Application Ref: 77167/APP/2023/2854

REFUSAL OF PLANNING PERMISSION

Site location: 48 Myrtle Avenue Ruislip HA4 8RZ

Description:
Conversion of roof space to habitable use including raising the ridge height and alterations to roof profile with 2 x rear dormers, 3 x front roof lights (revised description)

Applicant: MS & MRS ZAKIROV			
Job Title: 48 MYRTLE AVENUE, RUISLIP, HA4 8RZ			
Drawing Title: PROPOSED ELEVATIONS			
Scale: 1:50 Date: 24/09/23	Drawing No. PA3-21118-07	Print Size A3	Revision
Drawing Status FOR PLANNING APPROVAL

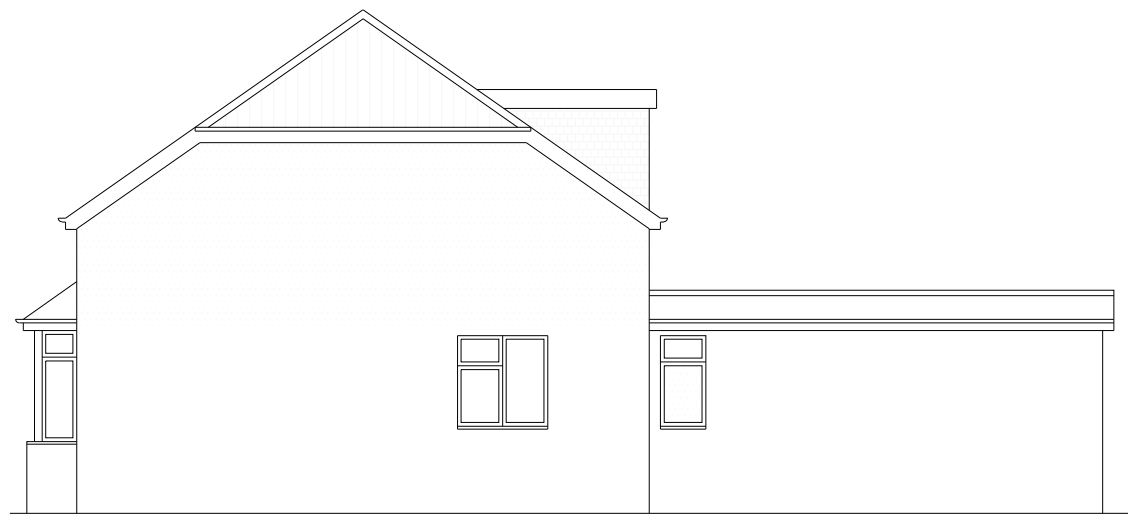
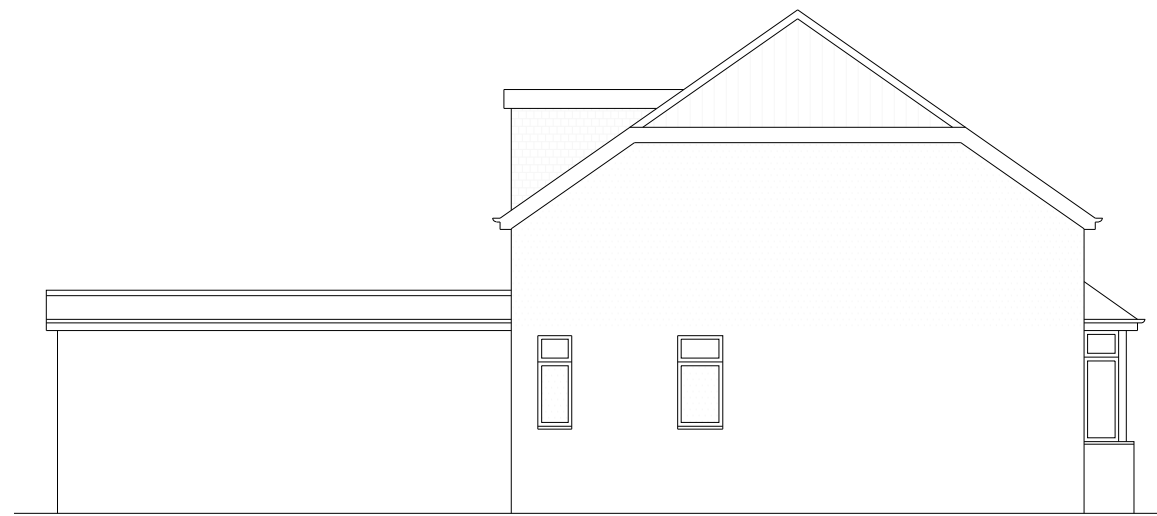
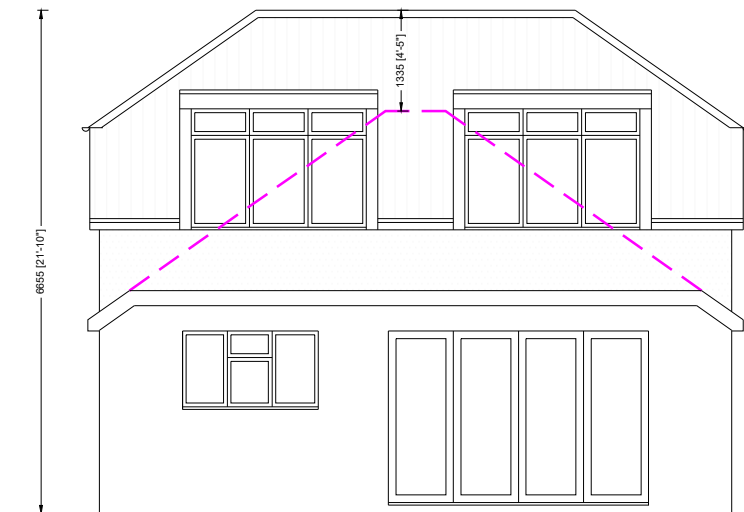
1. The proposal, by reason of its excessive width, depth, siting, scale, bulk, massing and design would be completely unduly prominent, visually incongruous and unsympathetic to the original architectural composition of the host dwelling, resulting in the proposed development having a harmful impact to original dwelling, and the character, appearance and visual amenities of the area. The proposal would therefore conflict with Paragraphs 130b) and 134 of the National Planning Policy Framework (2021), Policies D3 and D4 of the London Plan (2021), Policy BE1 of the Hillingdon Local Plan: Part One Strategic Policies (2012) and Policies DMHB 11, DMHB 12 and DMHD 1 of the Hillingdon Local Plan: Part Two - Development Management Policies (2020).
